# Advice Note

**Project Name:** Eastern Creek Data Centre Expansion Project (SSD-21342738-Mod-2) – Air Quality  
**Reference:** 26.1029.DR2V2

After a review of the AQIA, the NSW Department of Planning, Housing and Infrastructure (NSW DPHI) issued a request for additional information (DPHI comments) on 27 February 2026. The aim of this advice note is to provide a response to those comments related to air quality.

## 1. RESPONSE TO NSW DPHI COMMENTS

Figure 8 Buildings and discharge points considered in dispersion modelling (Scenario 1)

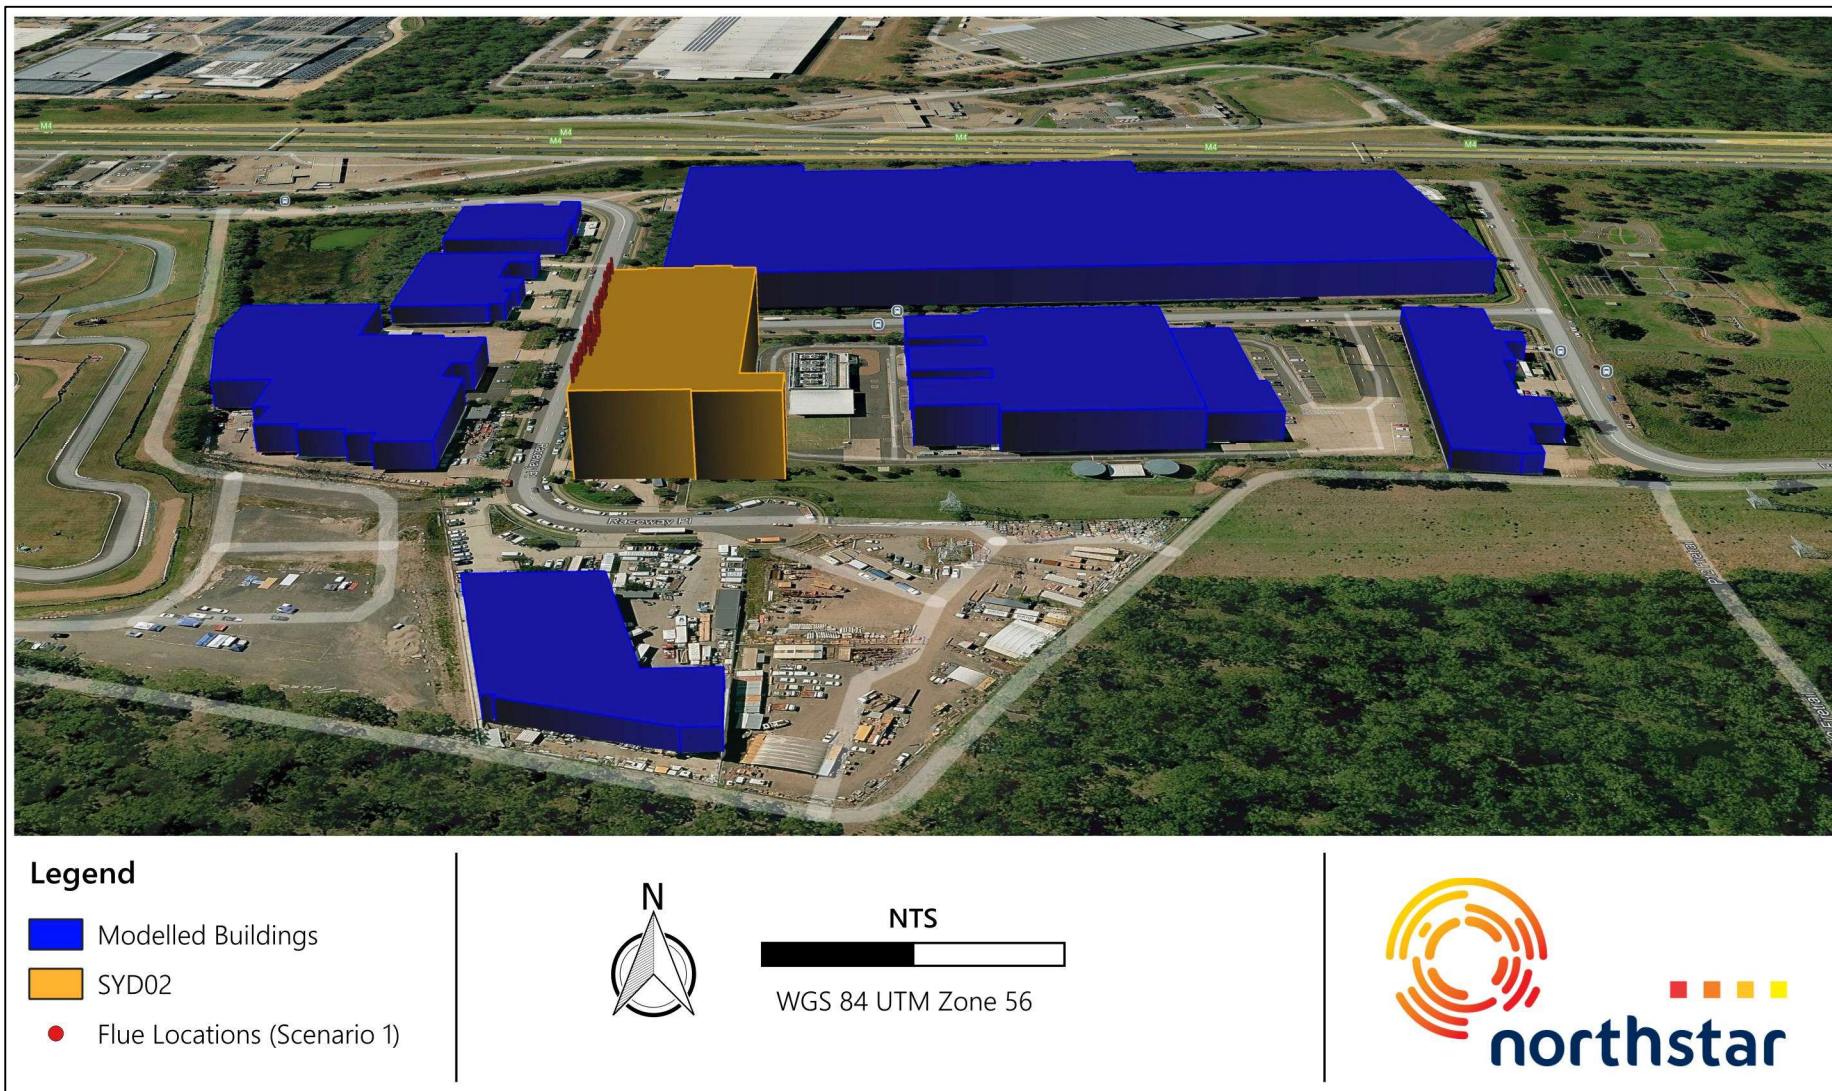
*Please provided an updated version of Figure 8 to ensure all potential sources have been accurately modelled. Consideration should be paid to the following:*

*a. based on the current figure, it is unclear whether emissions associated with the existing data centre's back-up generators have been included (and as per the original dispersion modelling)*

*b. based on the current figure, it appears an existing building on the eastern section of the site (already demolished to facilitate construction of the on-site substation) has been included as a barrier within the dispersion model. Please review and amend accordingly.*

Figure 8 of the Mod-2 AQIA (Northstar, 2025) has been reviewed to confirm that all relevant emission sources and influencing structures have been appropriately represented within the dispersion modelling interface.

The existing Eastern Creek Data Centre (under SSD-21342738) standby generators (six (6) units) were not included as quantitative emission sources within the dispersion modelling for the Mod-2 works. Potential cumulative impacts associated with existing on-site standby generation were instead considered qualitatively, consistent with NSW DPIE Cumulative Impact Assessment Guidelines for State Significant Development Applications (SSDA) assessment guidance. The first modelling scenario performed for Mod-2 assumes simultaneous operation of all proposed standby generators under Mod-2 to represent an appropriate evaluation of site emissions under peak operating conditions.

Figure 8 of the AQIA accurately identifies the emission sources included within the quantitative modelling and no amendment to the figure is required in relation to standby generators forming the modification.

The building previously located in the eastern section of the site has been demolished to facilitate construction of the on-site substation.

A review of the building wake inputs confirms that buildings included in the dispersion modelling were selected in accordance with the building wake algorithm (BPIP-PRIME), as referenced in the NSW EPA Approved Methods for the Modelling and Assessment of Air Pollutants in NSW regulatory guidance.

For the Proposal, the applicable building influence distance (5L), determined in accordance with BPIP-PRIME guidance (where L is the lesser of the building height or projected width), is approximately 181 m (refer Figure 1 below).

The demolished eastern building is located beyond the applicable building influence distance relative to the relevant emission sources and therefore does not influence building wake effects or dispersion outcomes presented in the Mod-2 AQIA.
